02nd June 2021

Antony Witherdin
 Director – Key Sites Assessment – DPIE
 City of Sydney
 456 Kent Street, Sydney
 NSW 2000

City of Sydney Review Response- Waterloo Metro Quarter

SECTION 1 1:50
COMMUNAL TERRACE - STUDENT ACCOMMODATION

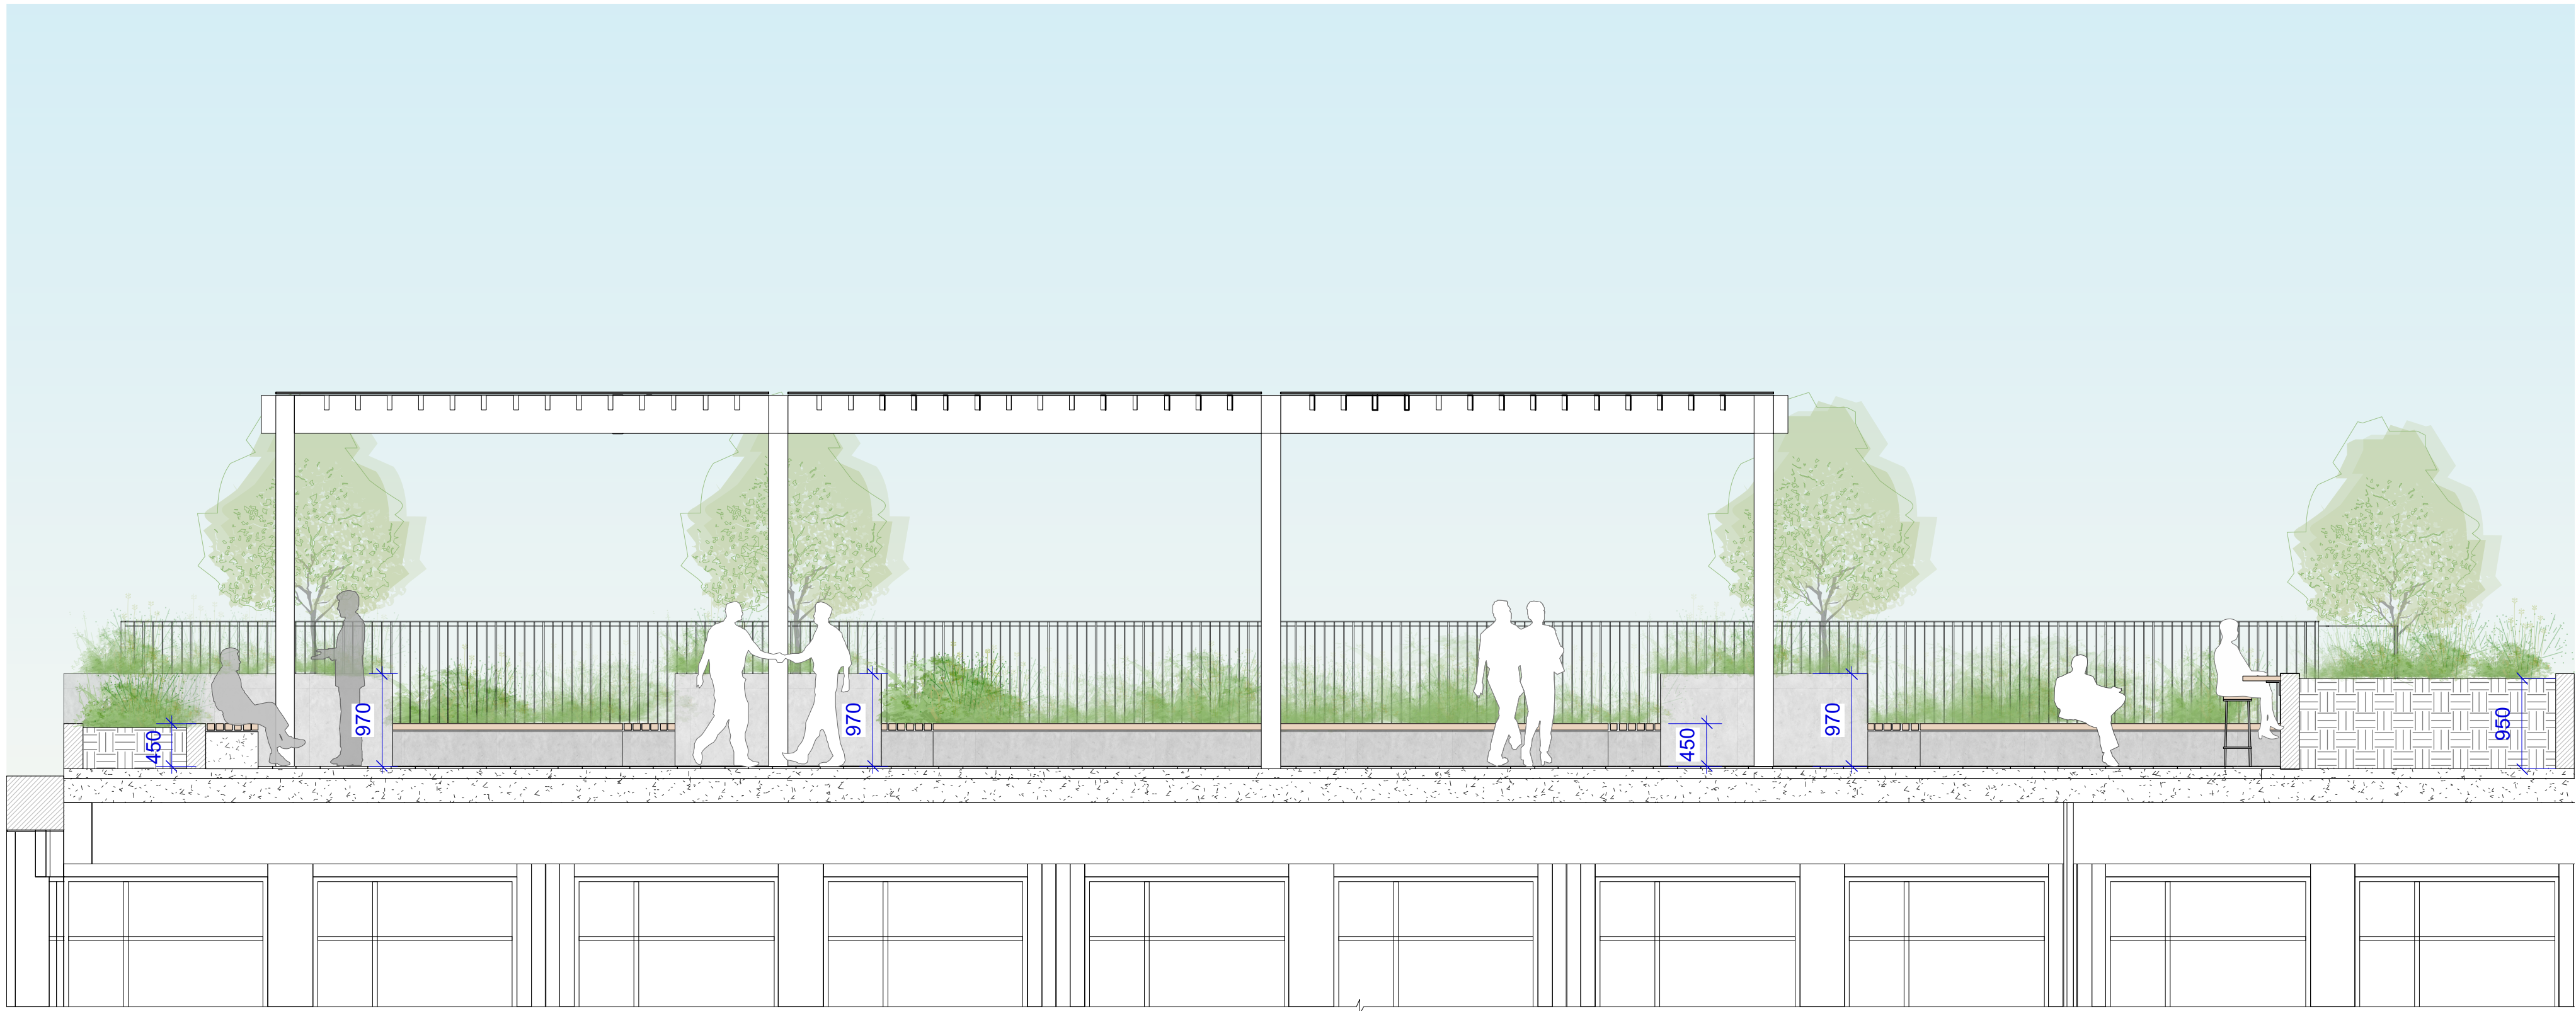
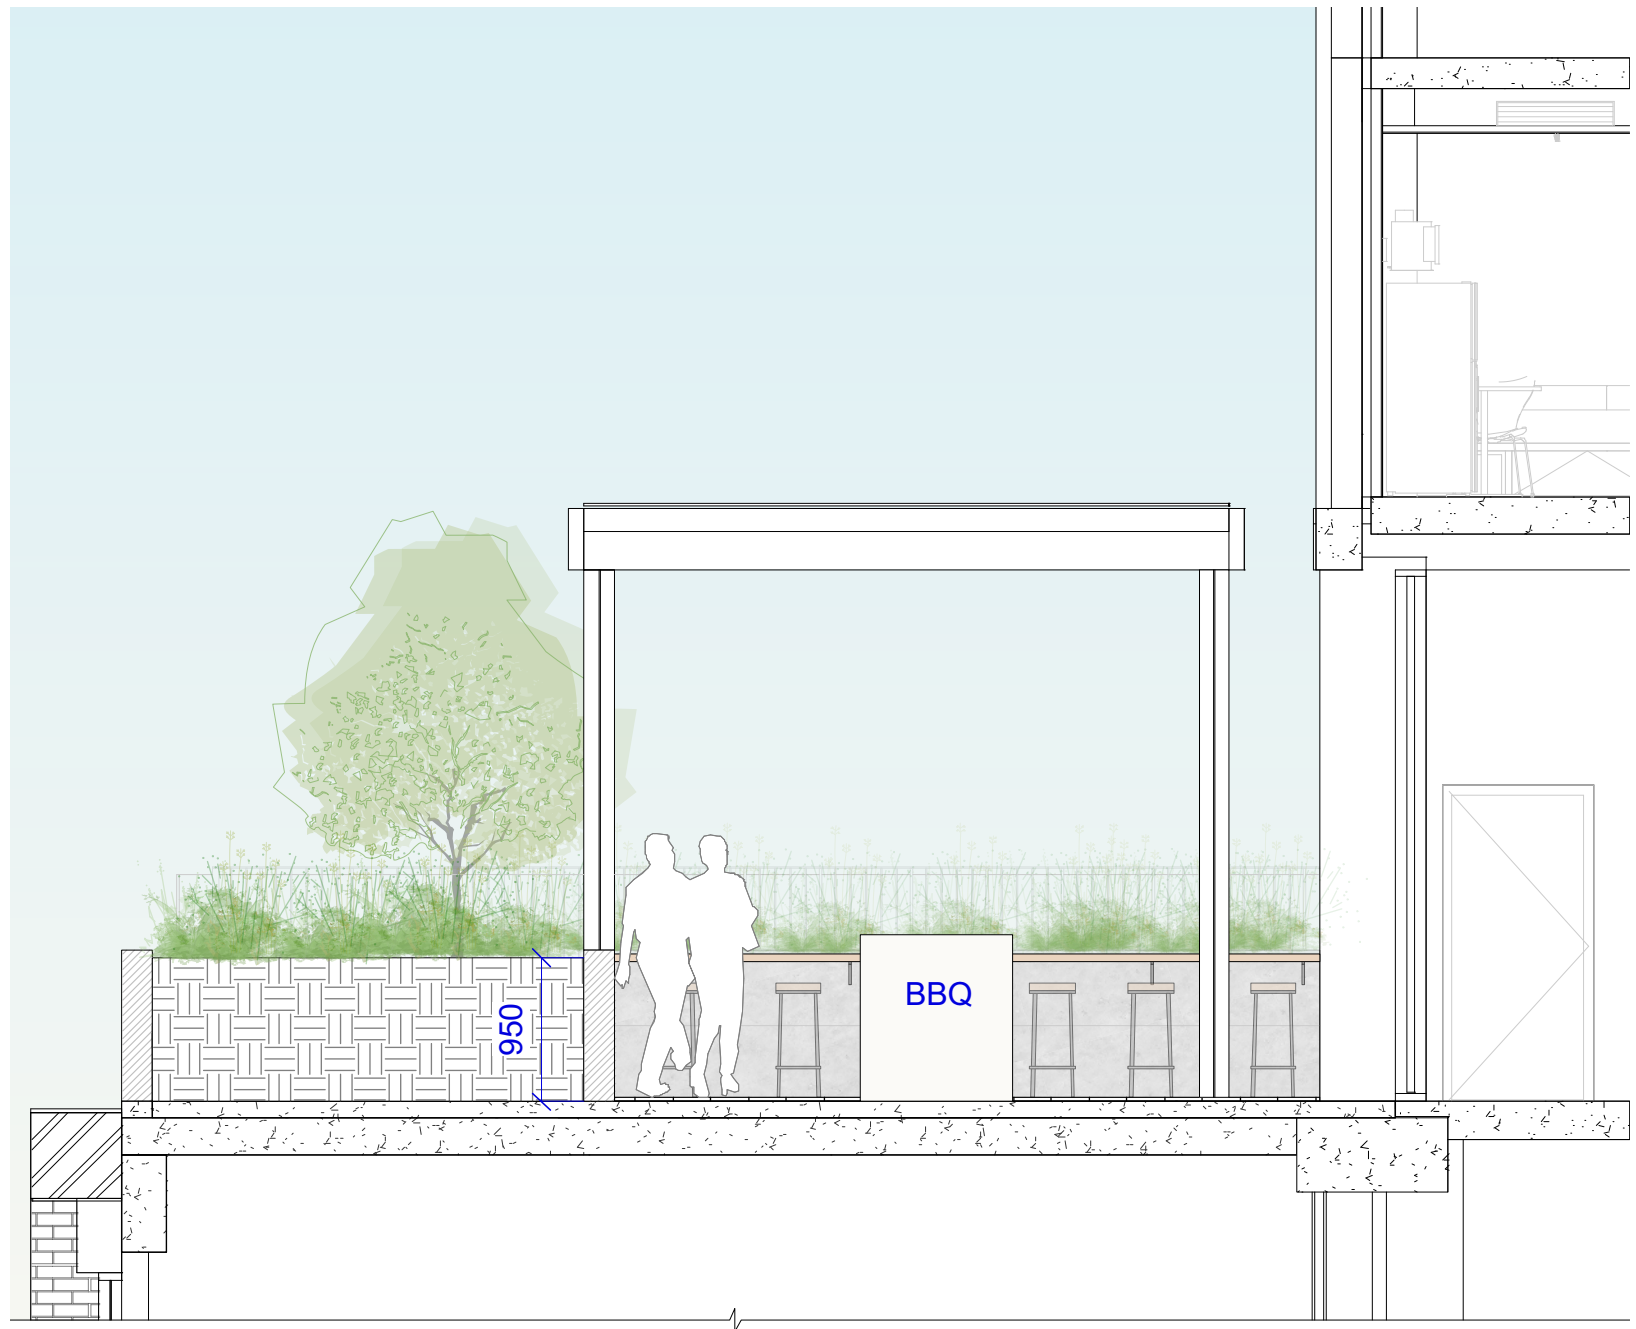
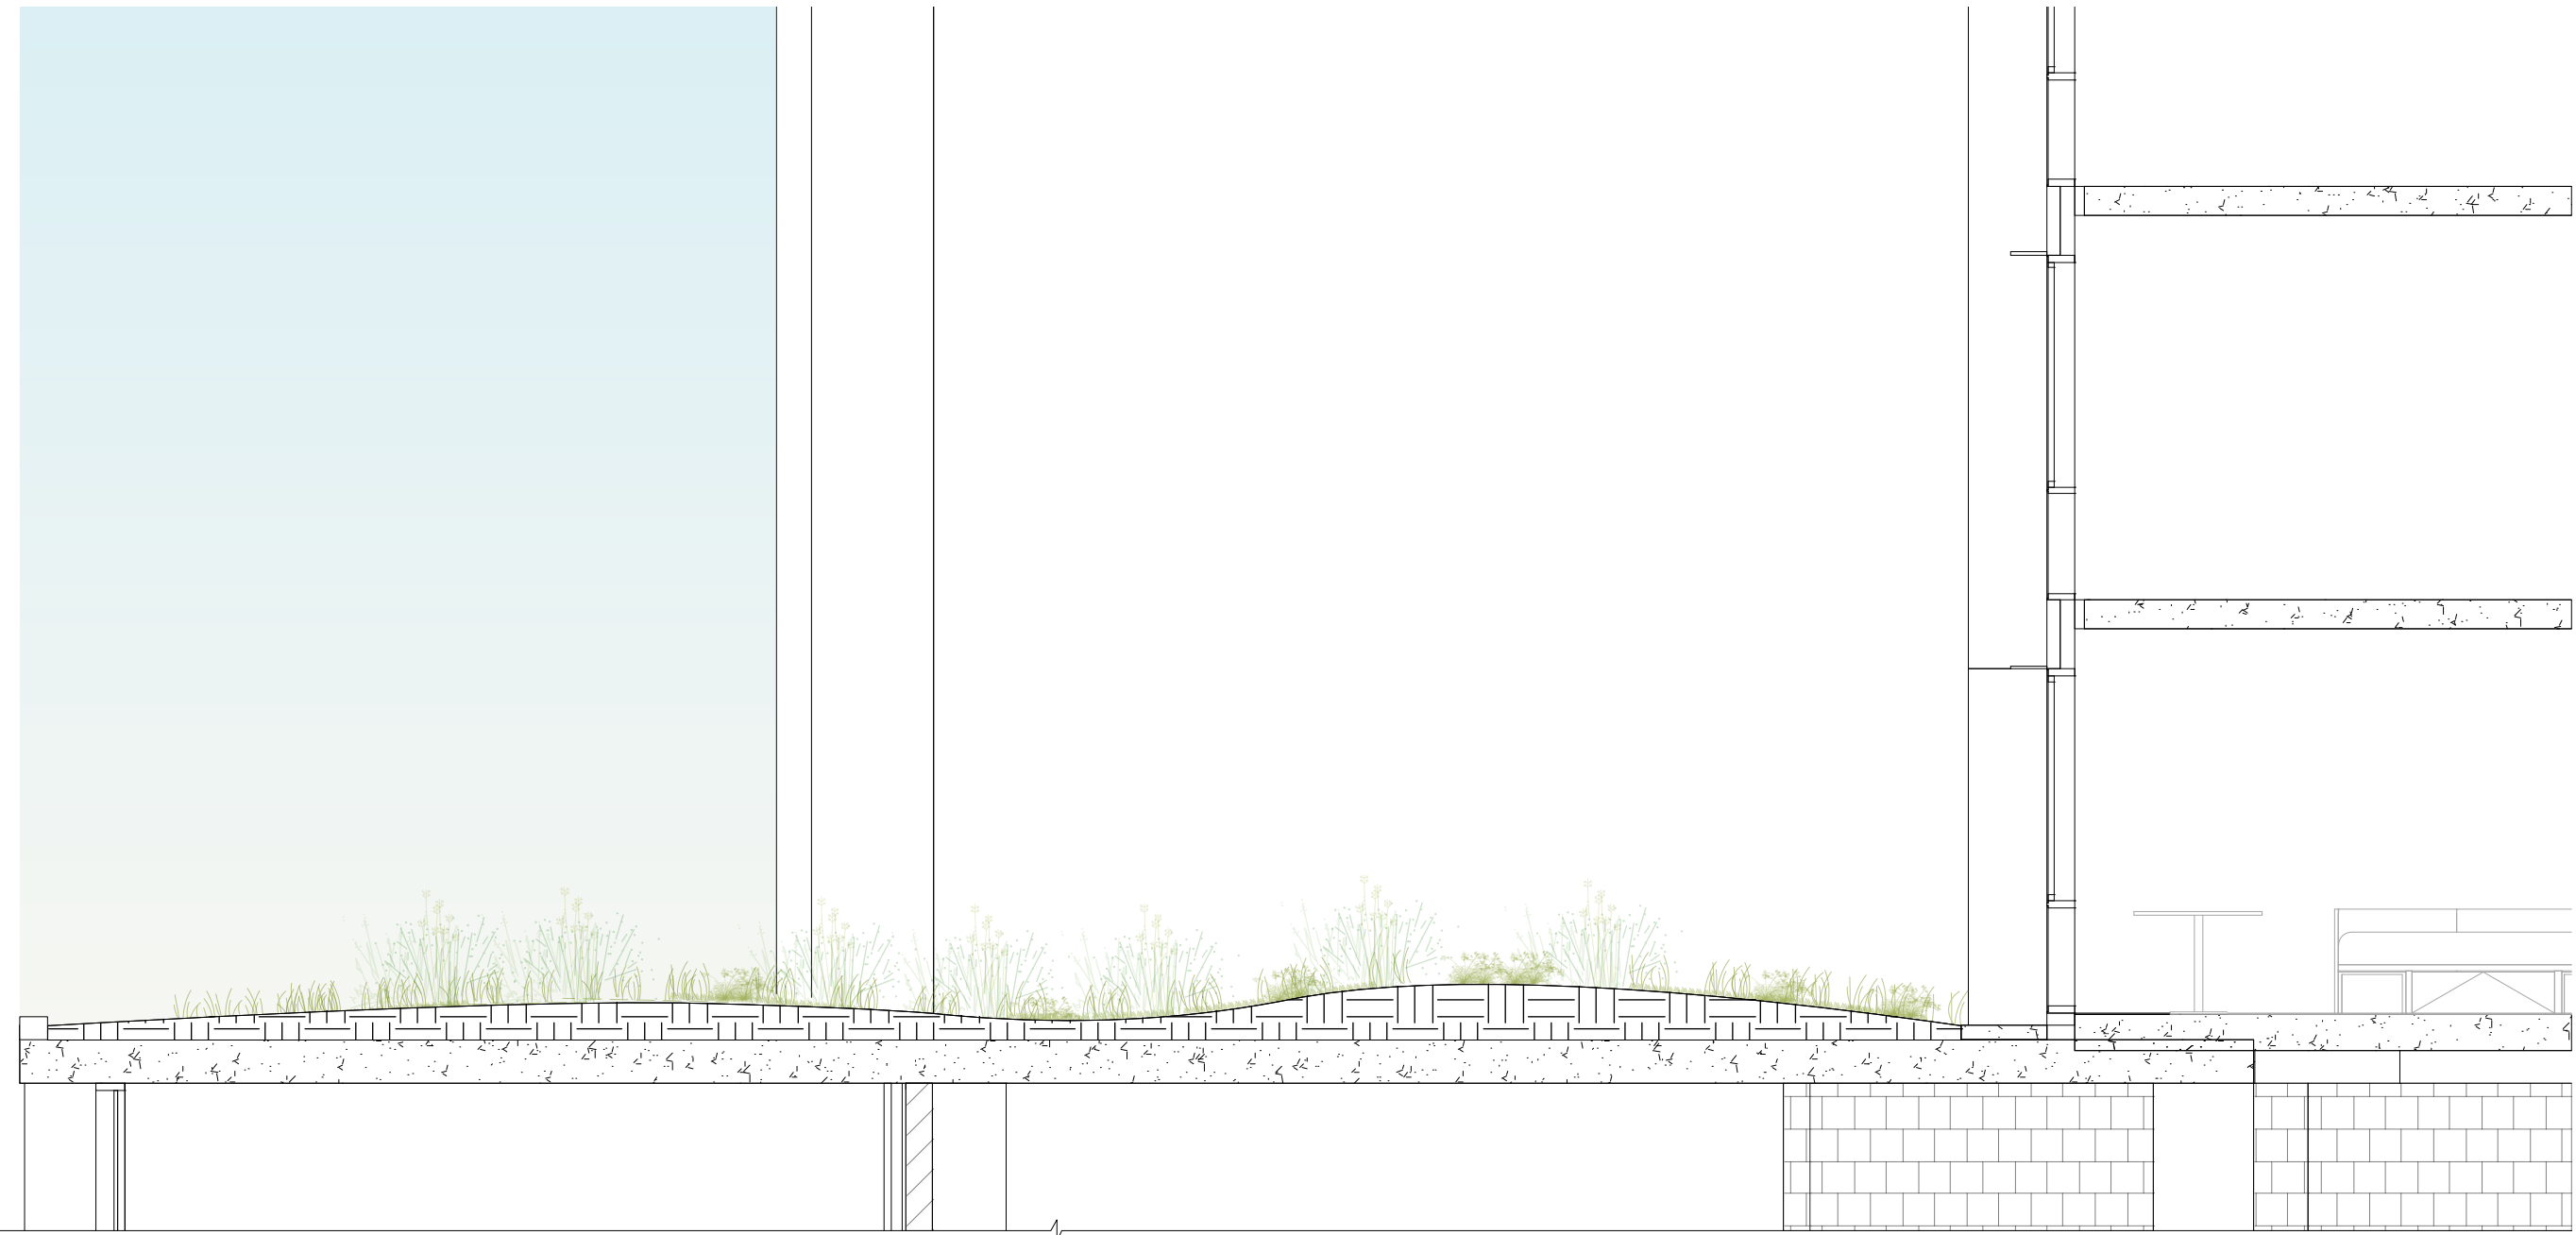
Landscaping		
47	As previously stated, the development relies heavily on the success of tree planting to mitigate wind impacts caused by the buildings. It is therefore imperative that all the recommendations of the wind report are incorporated into the conditions of consent.	Noted - Wind report recommendations have been incorporated. Please refer to response 12 for further detail.
48	A green roof is proposed to level 3 of Building 3. The section on drawing WMQ-BLD3-ASP-LS-DA304 illustrates substrate that mounds up but also tapers out to almost nothing. This is not supported, and the edge should be increased to a minimum depth of 200mm or 400mm, depending on the intended species.	Noted - A minimum depth of 200mm will be provided to inaccessible green roofs to ensure there is sufficient soil depth for plants to establish. Localised mounding to 400mm will be provided where possible to increase soil volume and allow variety in plant selection. Refer updated section WMQ-BLD3-ASP-LS-DA304
